Re: REQUEST FOR ADVICE

PROPOSAL:	LOT 375 DP 1191360
ADDRESS:	LOT 375 GALLIPOLI DRIVE, EDMONDSON PARK NSW 2174

Liverpool City Council was invited to provide comments on a request for SEARs for a S4.55(1a) Modification Application to SSD 10224 in relation to the new Primary School at Edmondson Park, Buchan Ave, Edmondson Park.

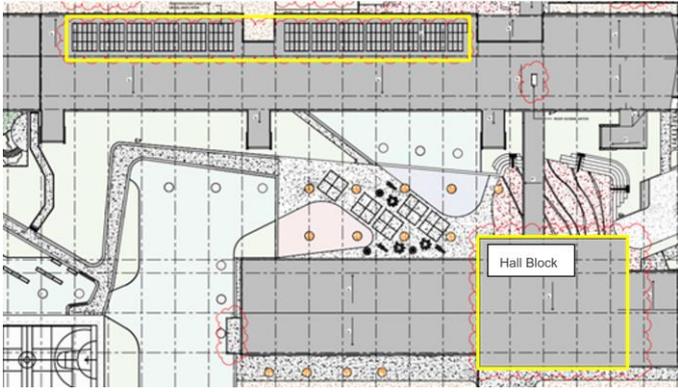
2. The modification application also includes addition of five (5) mechanical enclosures across the site; three of them are to be located along Faulkner Way and one along the Buchan Avenue. The planning statement prepared by Gyde Consulting, dated 02 March 2022, indicates that the enclosures proposed along Faulkner Way will have a minimum setback of 1050mm from the boundary allowing for soft landscaping to be provided between them and the street. However, this information is not consistent with the architectural and Landscape Plans accompanying the application. As per the amended architectural plans prepared by TKD architects the northern enclosure (along Faulkner Way) measures only 750mm from the property boundary. The proponent needs to clarify this.

Notwithstanding the abovementioned inconsistency, Council is of the opinion that the enclosures can be considered acceptable, should adequate planting be provided to screen them from the street in order to minimise their visual effect.

Figure 4: Height of Solar Panel within highlighted area. Height limit in green dash (Source: TKD architects)

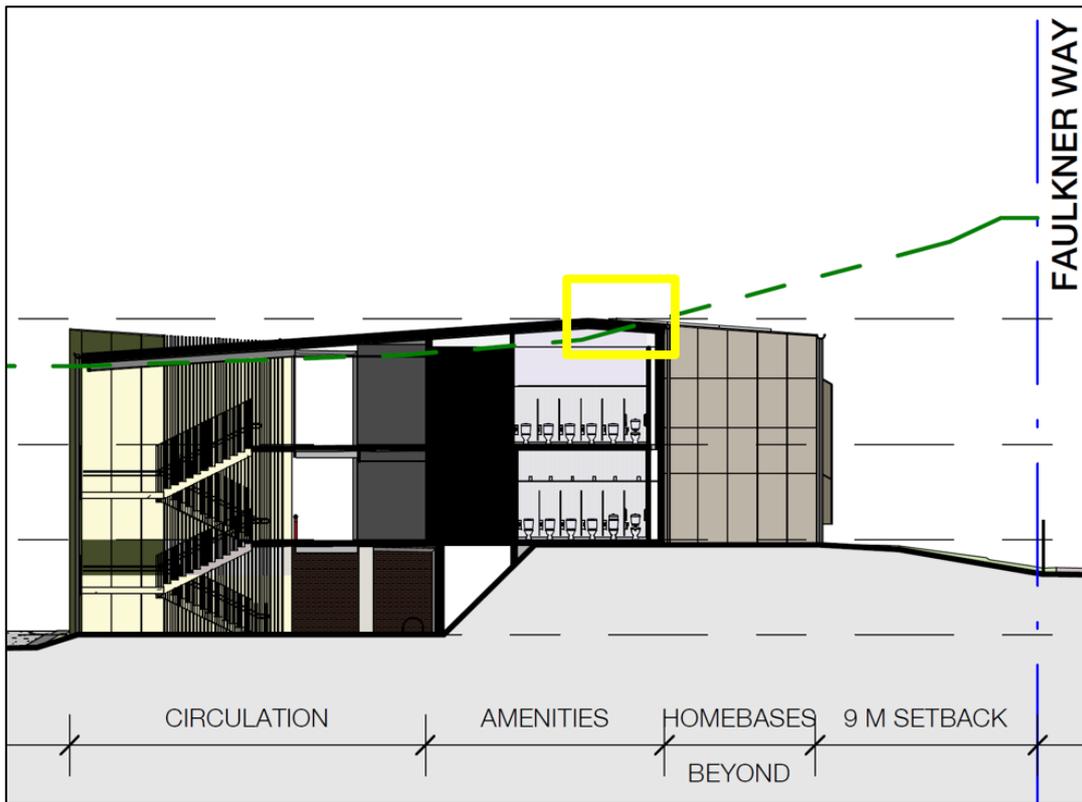
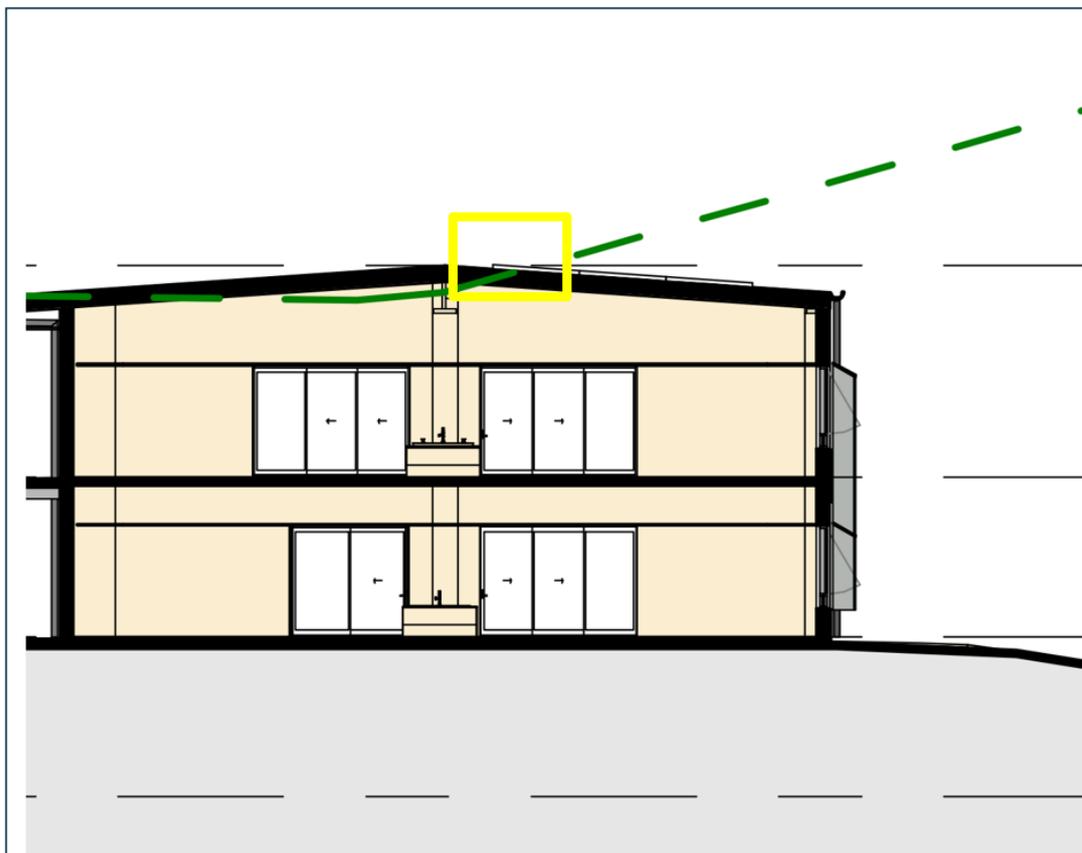
1. The proposed amendments to the location of the solar panels from the roof of Block B to the roof of Block A and additional PV panels to increase the overall capacity of the system is considered to be acceptable. However, the proposed relocation of the panels and additional panels would result in minor increase in the height of the building of Block A, particularly along the western side.

In accordance with clause 18 – Height of Buildings – Appendix 16 of the State Environmental Planning Policy (State Significant Precincts) 2005, a 15m height

control applies to the site. Block A as approved, already exceeds the maximum building height by 0.5 to 1.6m along the ridge line and proposal would result in minor increase in the extent of the breach. Notwithstanding, the non-compliance, the proposed amendments to the solar panel are considered acceptable for the following reasons:
